Our Ref: A/80/20/NMA

Non material amendment following the grant of A/85/18/RES for amendments to House Type 3 (Unit C) footprint and internal layouts and subsequent amendment to proposed site plan.

Land between New Place Bungalow and Arundel Road Angmering BN164ET

COMPARATIVE
ELEVATIONS

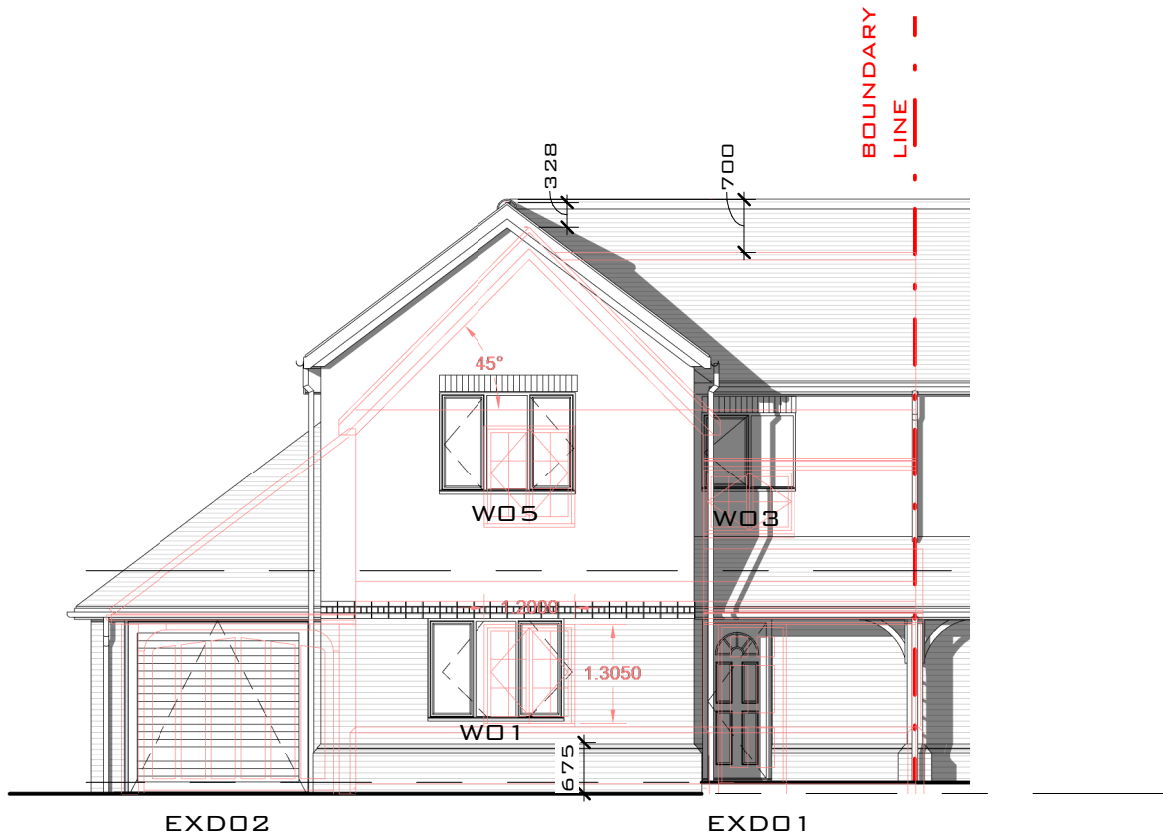
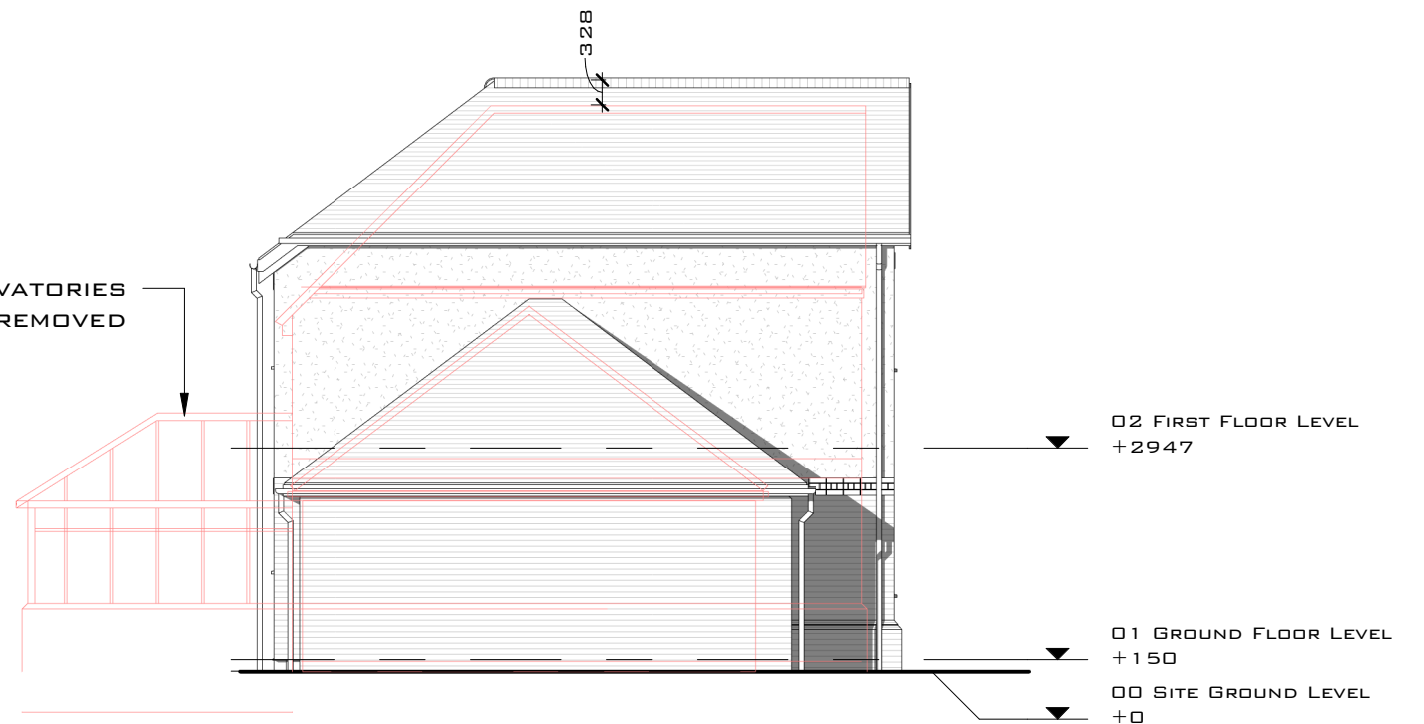
From the information submitted I am unable to take the alterations as a Minor Amendment to A/85/18/RES. The reasons that these proposals have not been accepted as a Non-Material Amendment is because they increase the height of the roof of Plots 5 and 6 by more than 0.3m and Plots 1 and 2 are moved more than 1m to the north. They cannot therefore be considered under section 96A of the Town and Country Planning Act 1990.
